From: Polly Harris-Gorf
Sent: 13 April 2022 08:56
To: _planningadvice
Subject: FW: 21-L74 - PLOT 9 HOLBEACH - REF: H09-0253-22
Attachments: We sent you safe versions of your files; 21-L74-C201 - AJS - PROPOSED ROOF PLAN AND SECTIONS.pdf

Drawing Number: 21-L74-C201

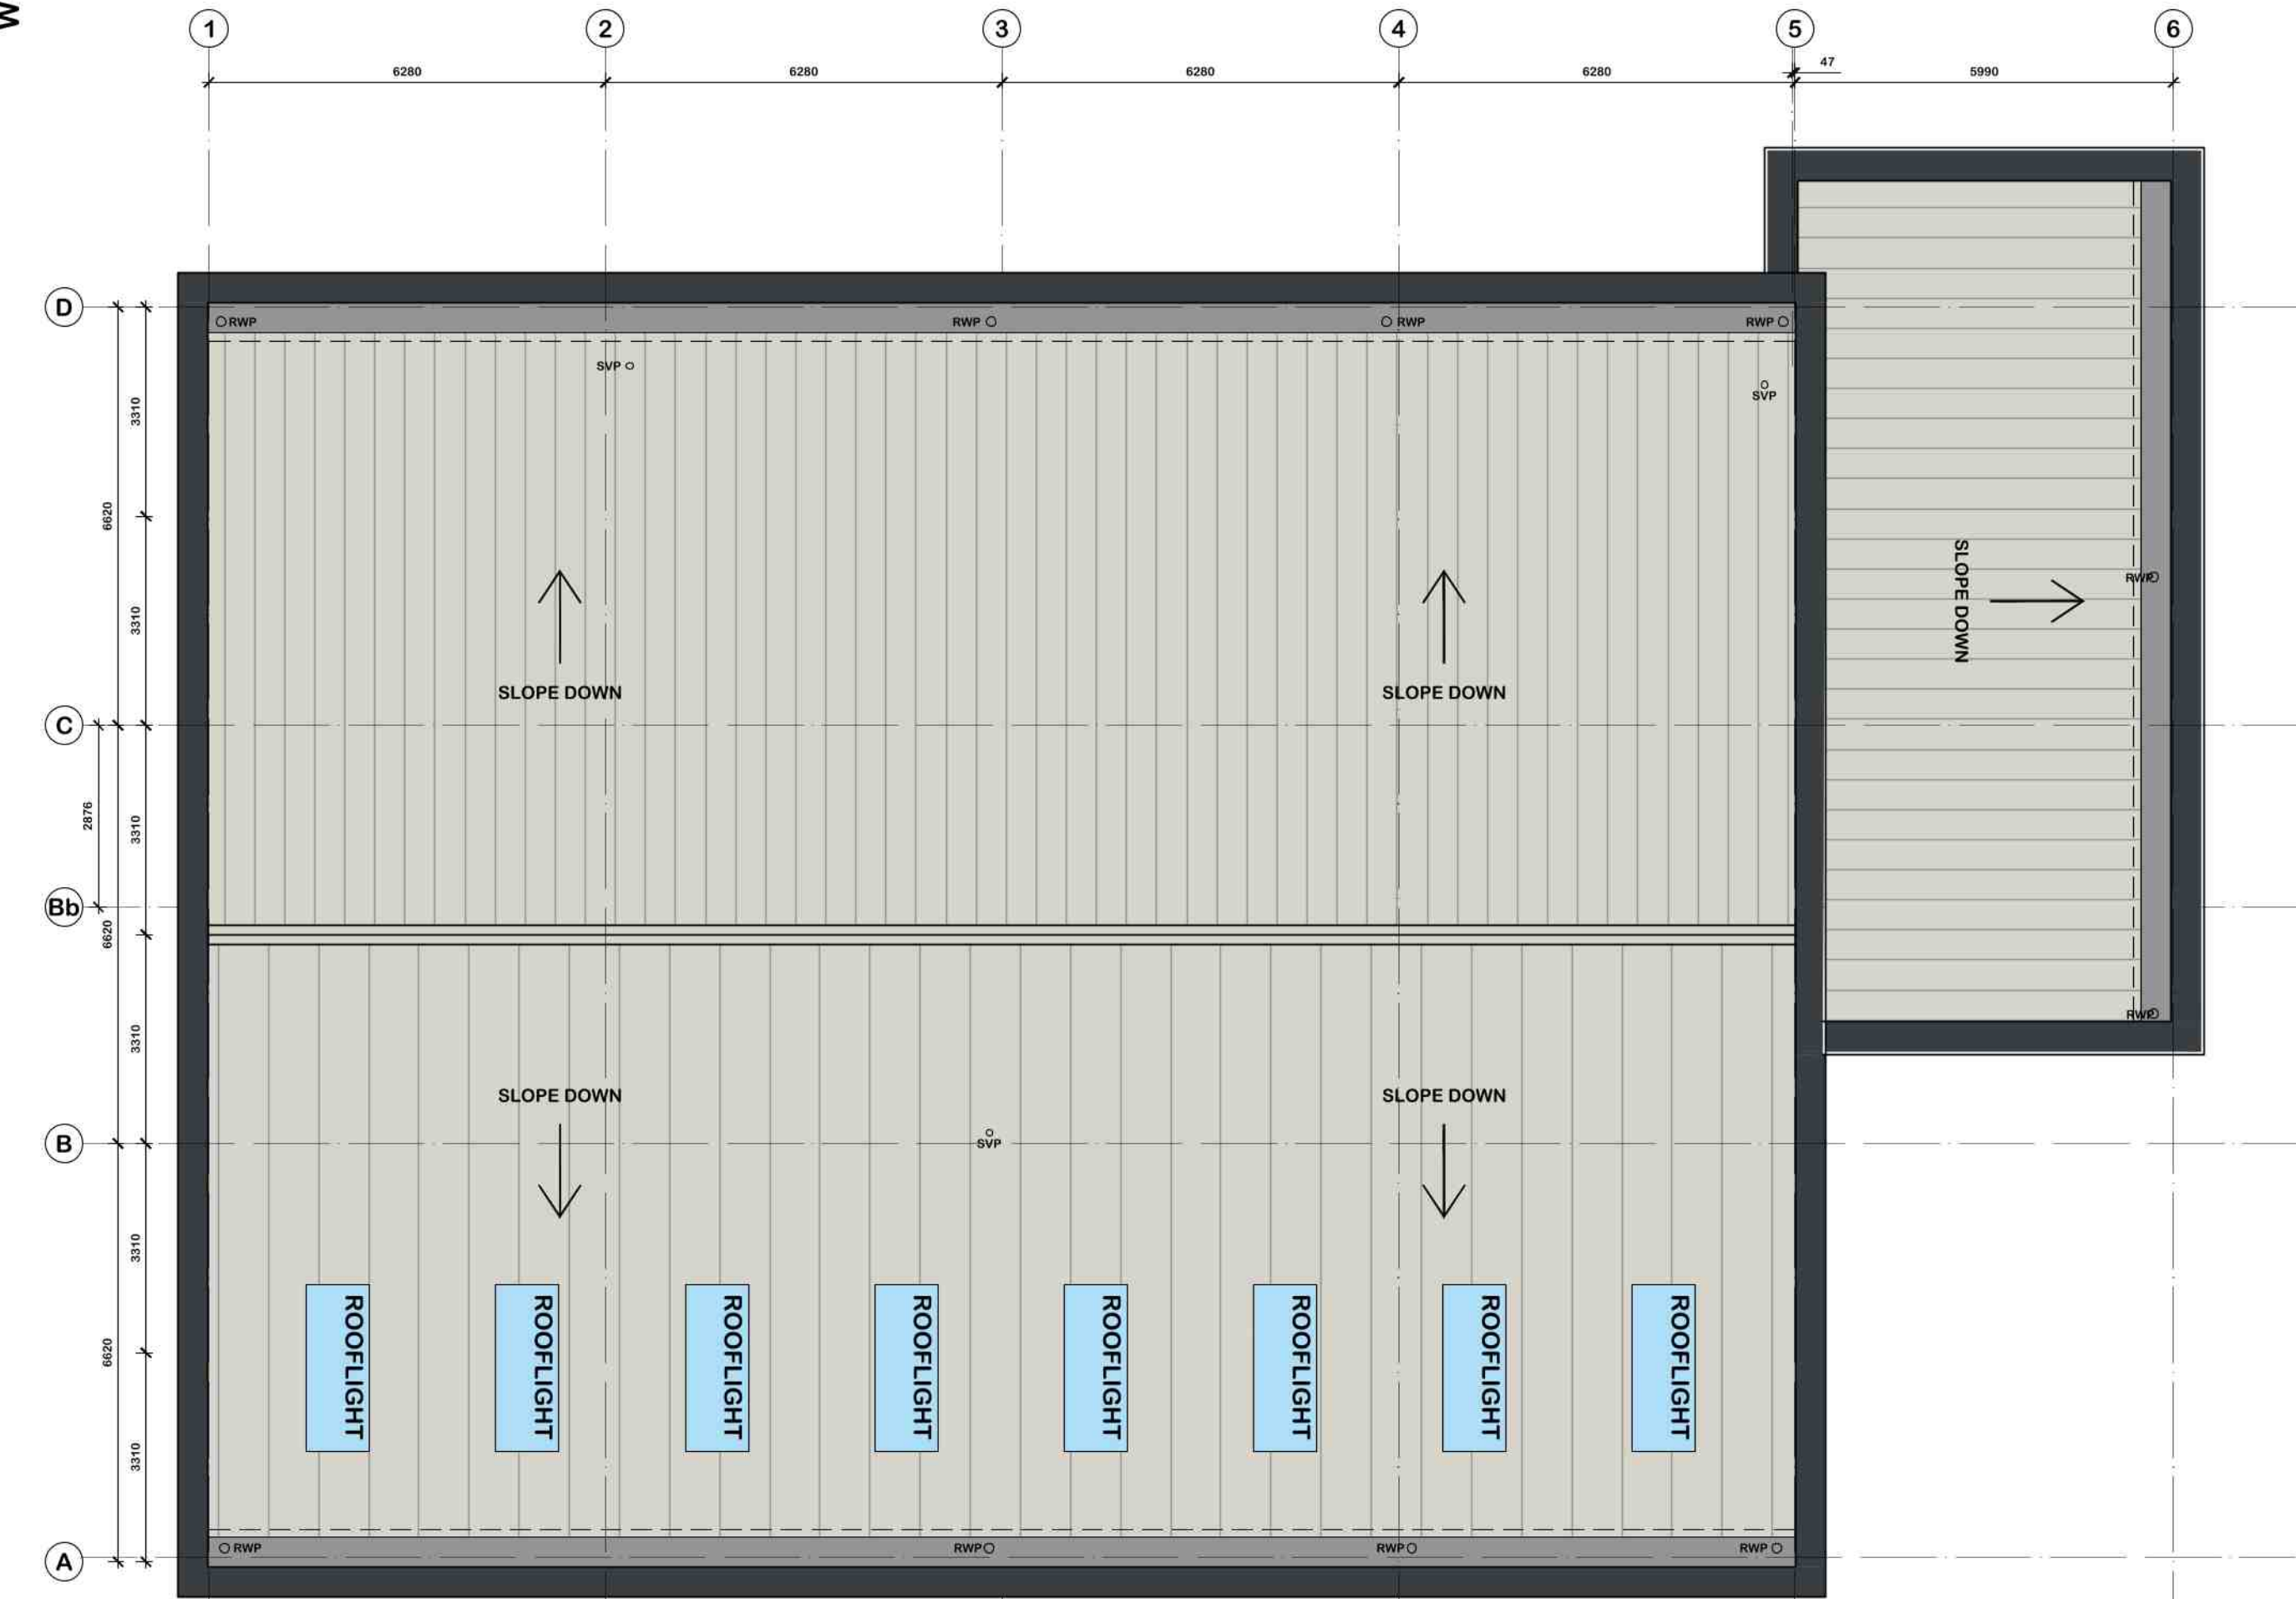
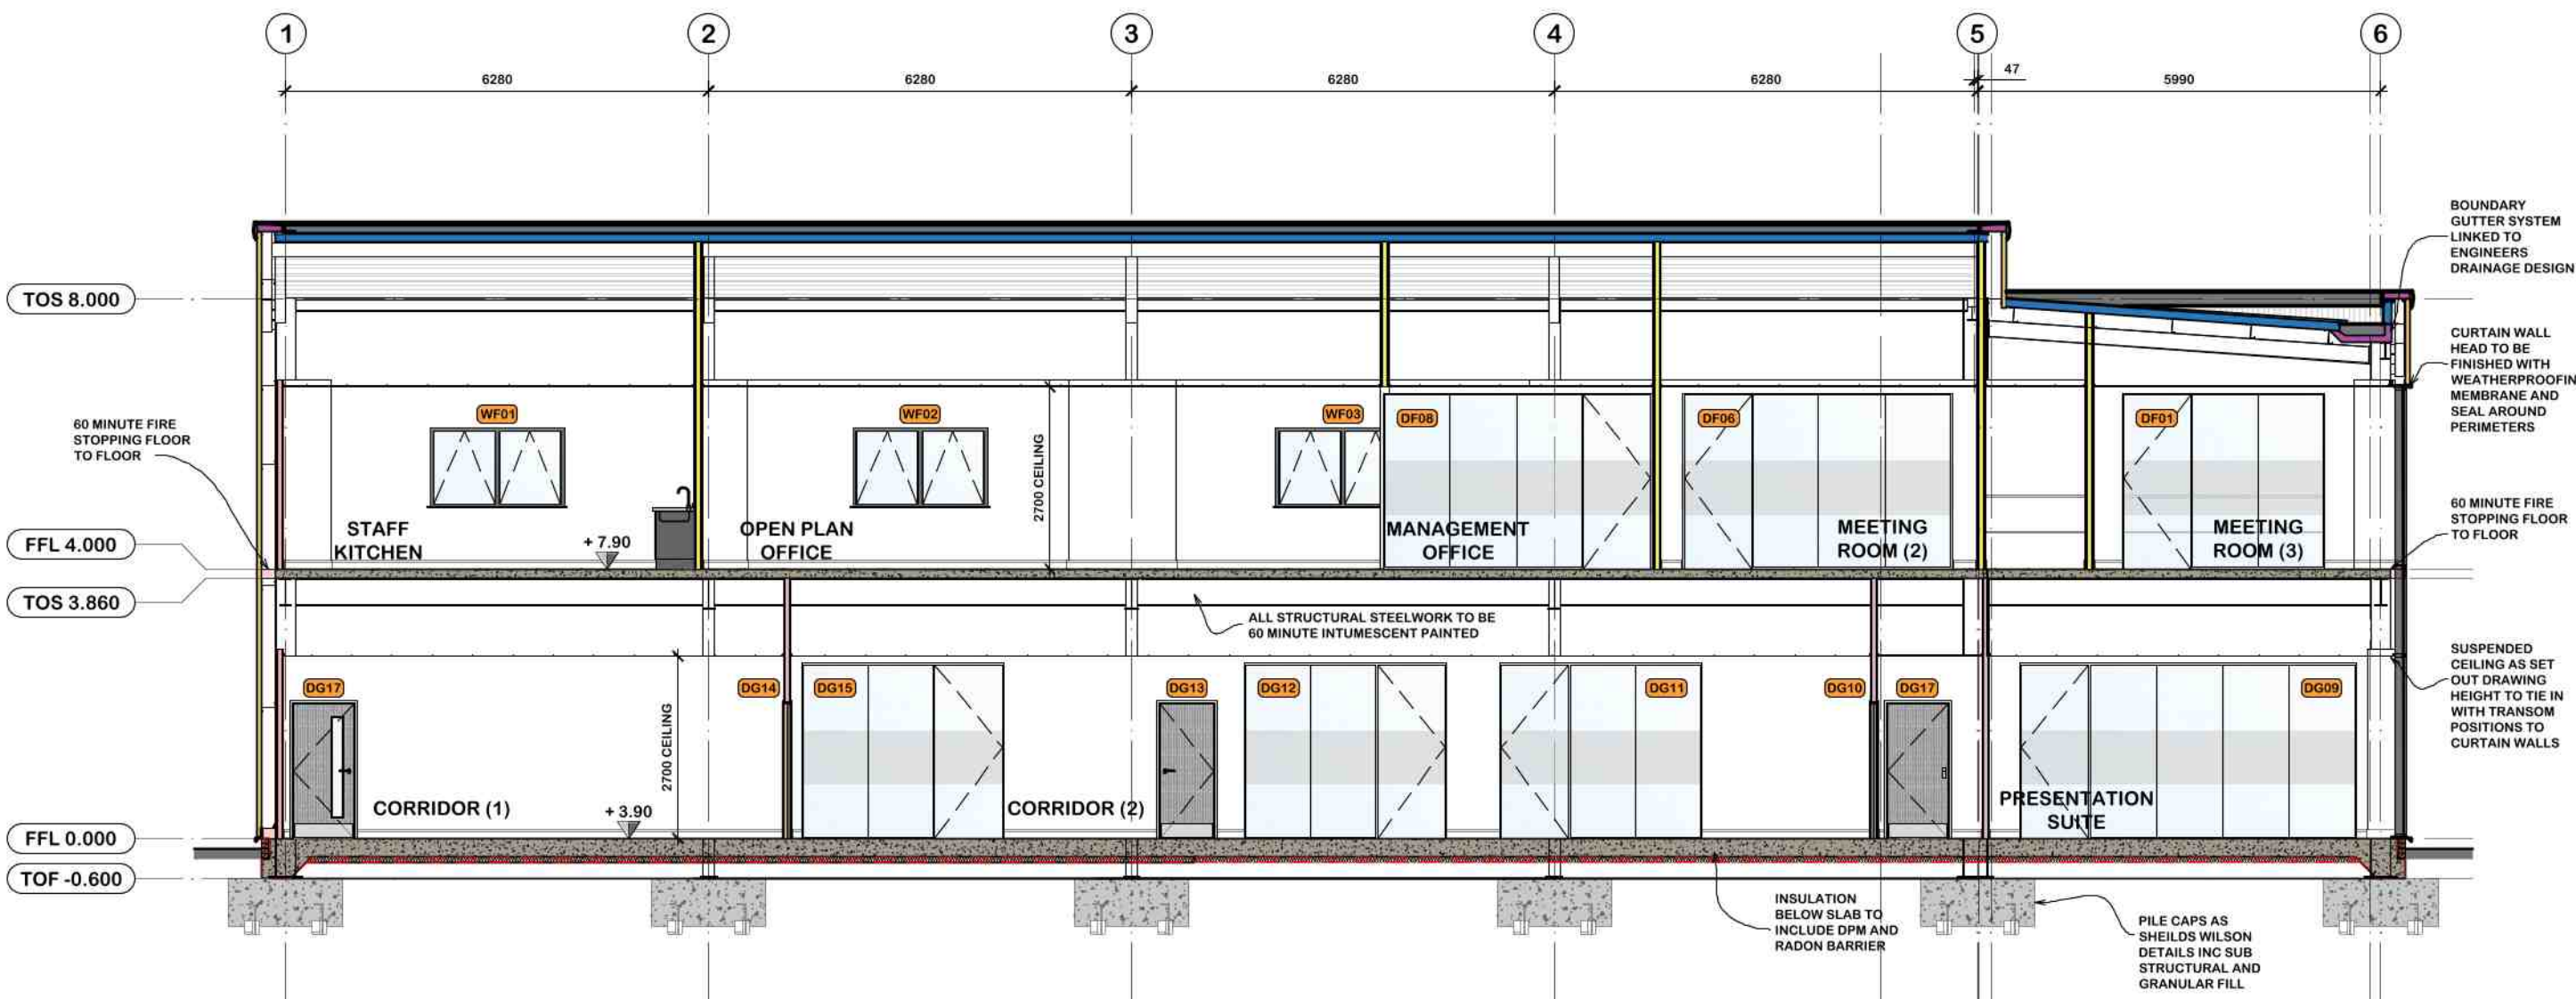
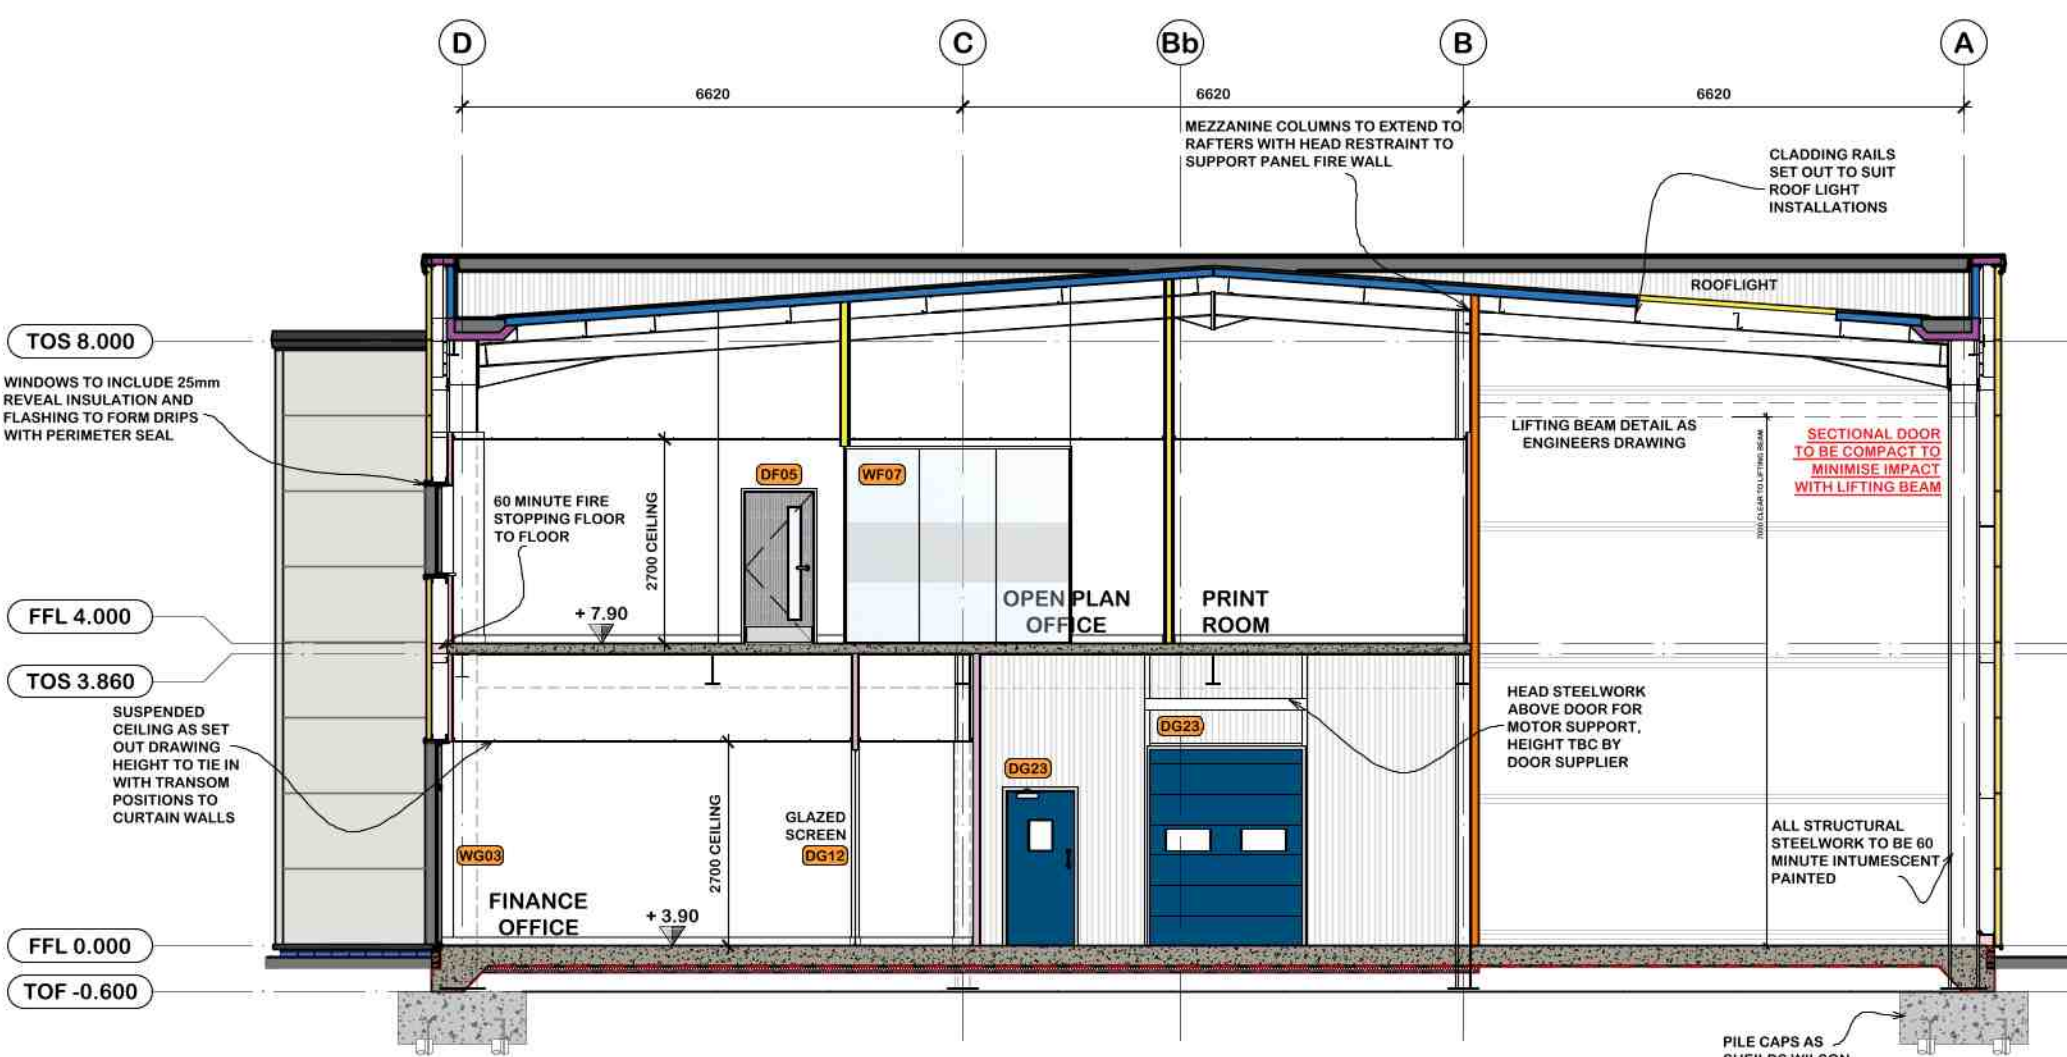
Further to your submission below, please can you address the concerns of the SHDC Environmental Protection Officer and the Internal Drainage Board, that can be viewed on line at this link.

Site specific section drawing attached which are to be utilised across the development building as requested, the project specifications have detailed the requirement for Radon barrier throughout the Ground floor slab.
